February 16, 2018

RE: **Kidz Academy**
McMahon and Fineland NW
Grading Plan and Drainage Report
Engineer's Stamp Date 2/12/18 (File: A11D016)

Based on the information provided in your submittal received 2/12/18, the Grading Plan and Drainage Report cannot be approved until the following are corrected:

TYP. ORIFICE PLATE DETAIL
N.T.S.

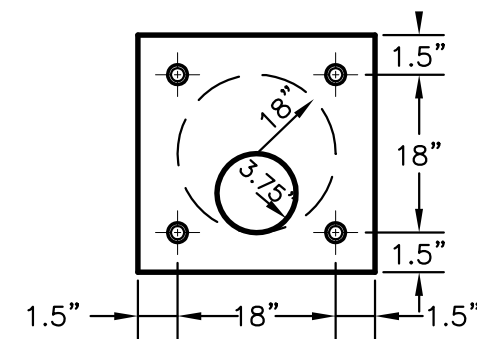
3. If no longer under common ownership, provide written permission from the adjoining landowner (Lot A1B) for grading and work on their property.
4. The AHYMO model shows the pond as having outflows beginning at elevation 85.52', but on the plan, the inlet grate elevation is at 87.25'. Please clarify the routing. Is this outflow from Basin A bypassing the pond and going right to the orifice plate inlet?

DETAIL A
TO BE INSTALLED @ THE OUTFLOW
OF THE CATCH BASINS (SEE THIS PLAN
FOR ORIFICE PLATE SIZES)

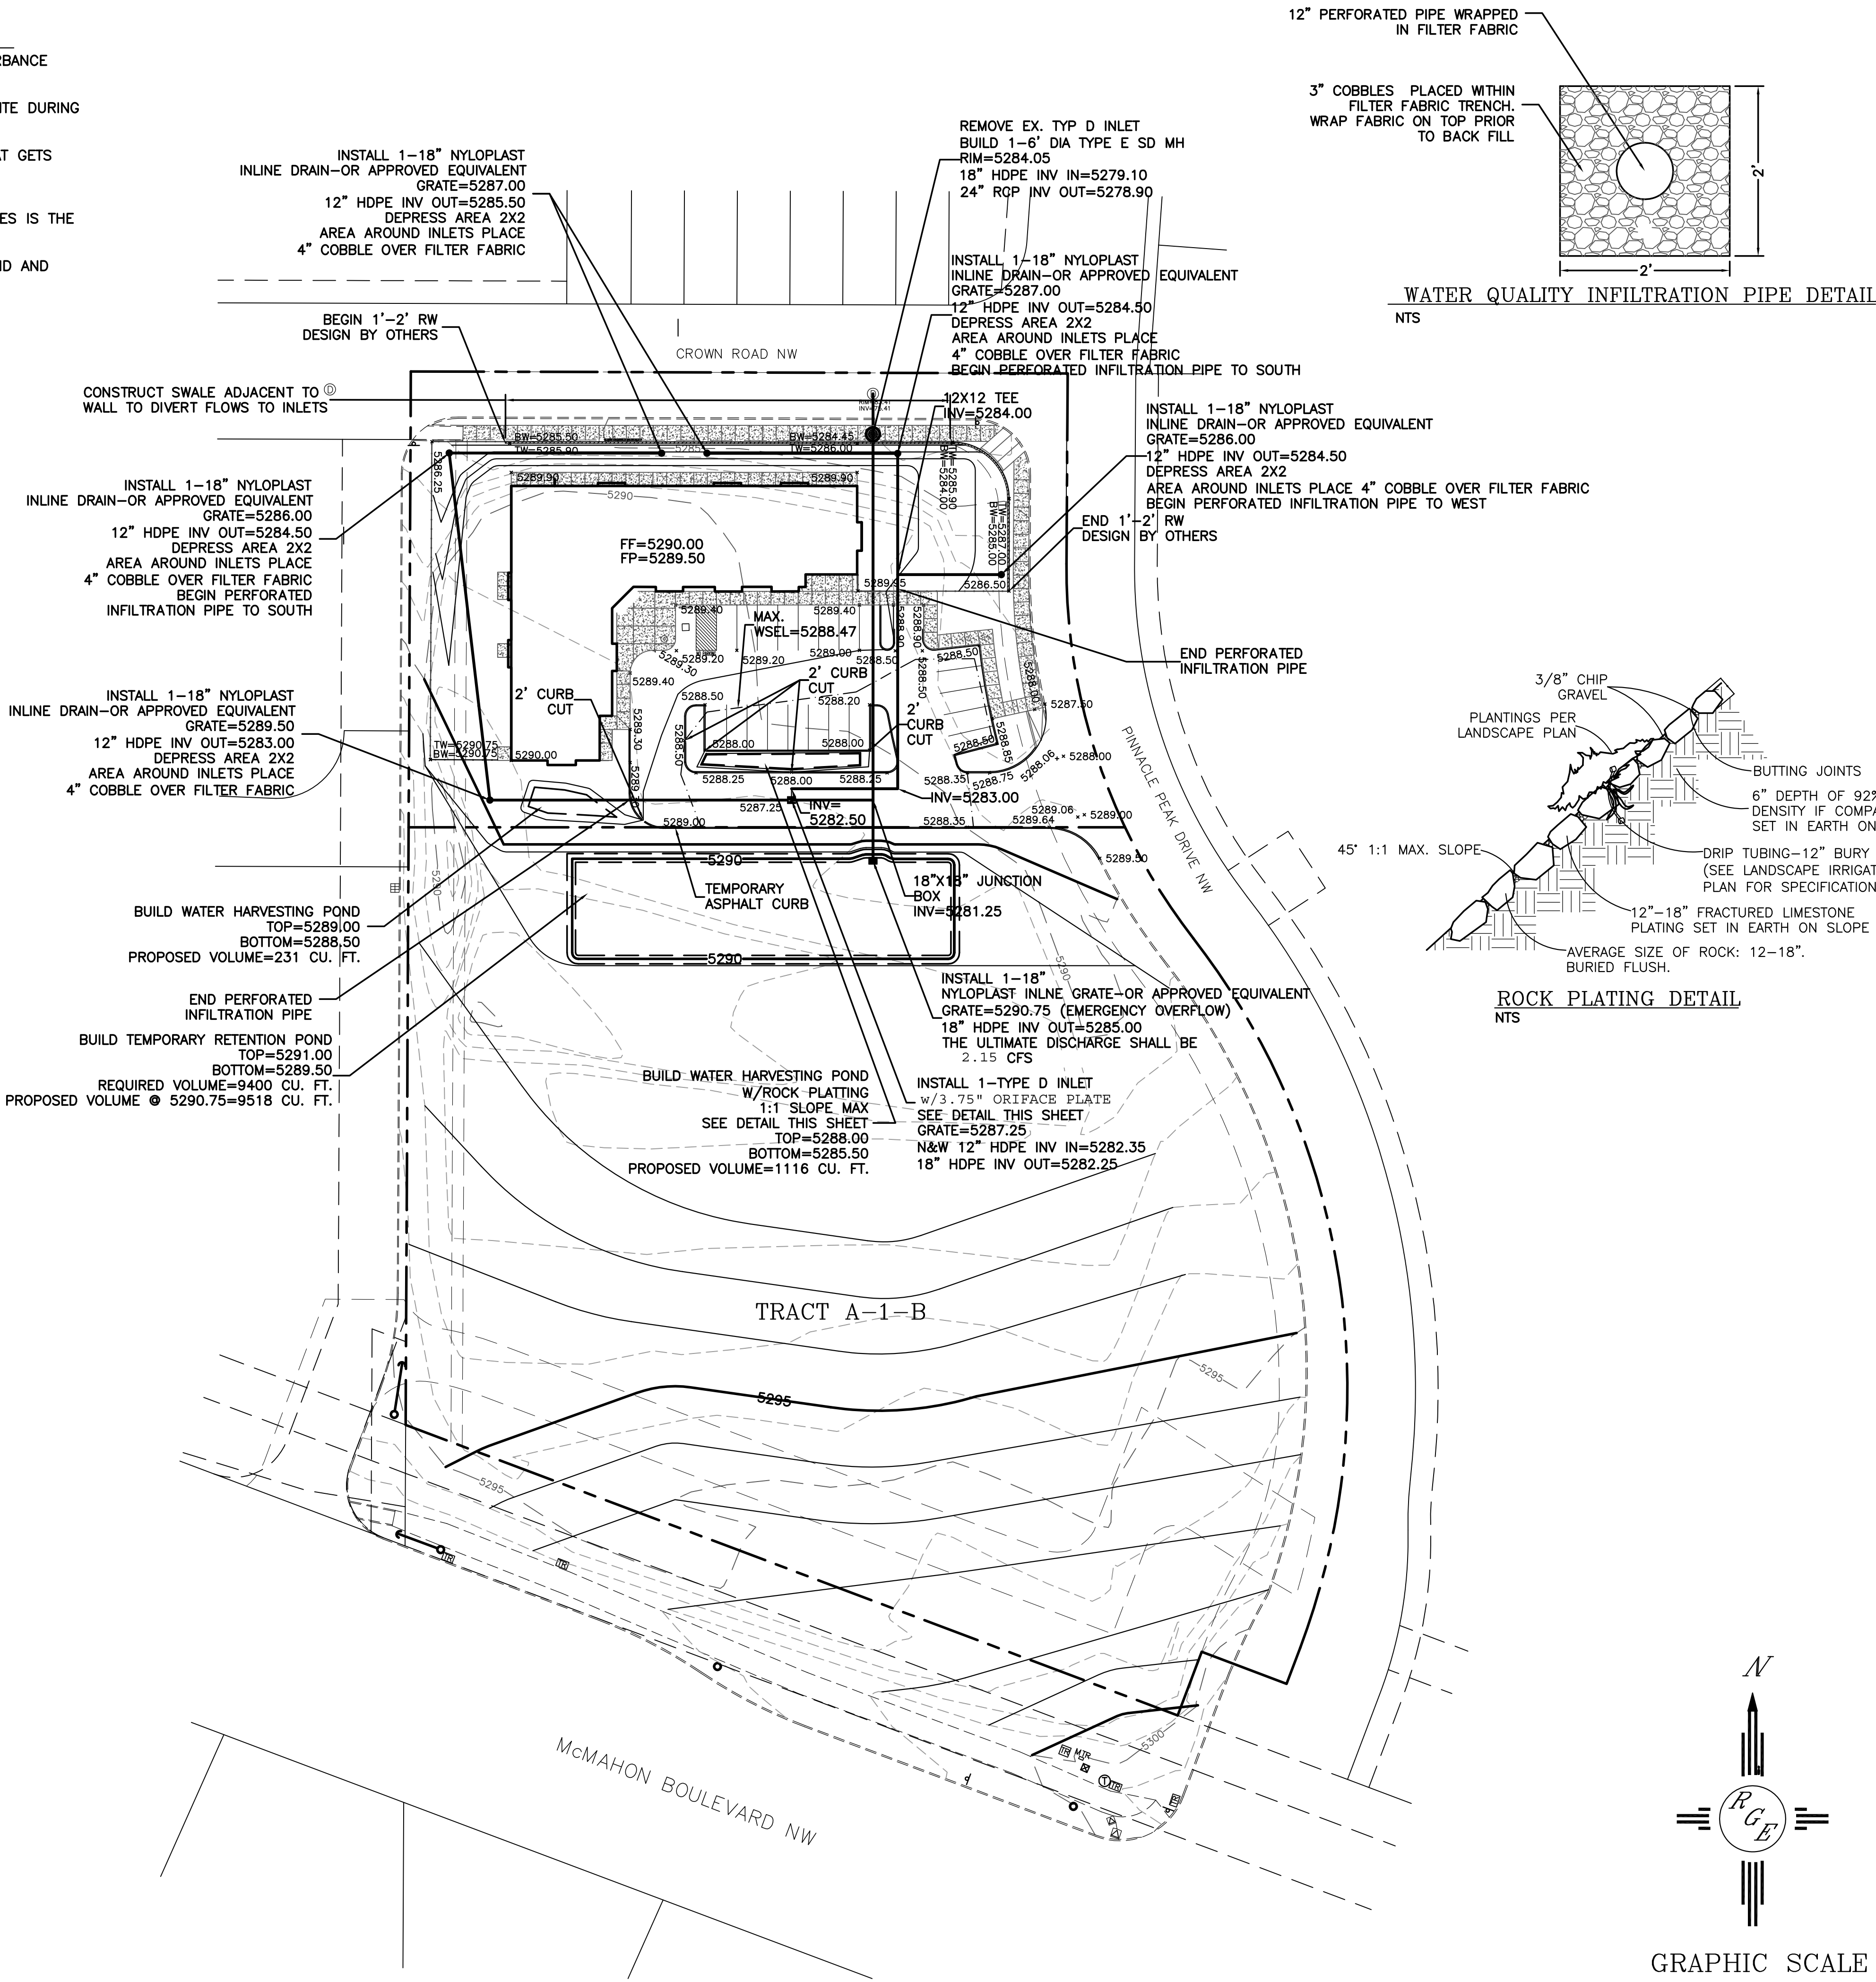
5. What is the function of the storm drain w/ inline drains around the building? Previously these were used for routing the roof drains to the orifice plat/inlet near the pond, but now they seem to be just for area drains to capture runoff from Basin A. If so, they do not appear to be placed where they will intercept all flows from Basin A.

6. The small amount of impervious area in Basin A does not appear to be routing through any first flush pond. It appears to either free discharge onto Crown Rd or get routed through the orifice plate/inlet, but not get retained anywhere. If true payment, of Fee-in-Lieu will be required for this impervious area.
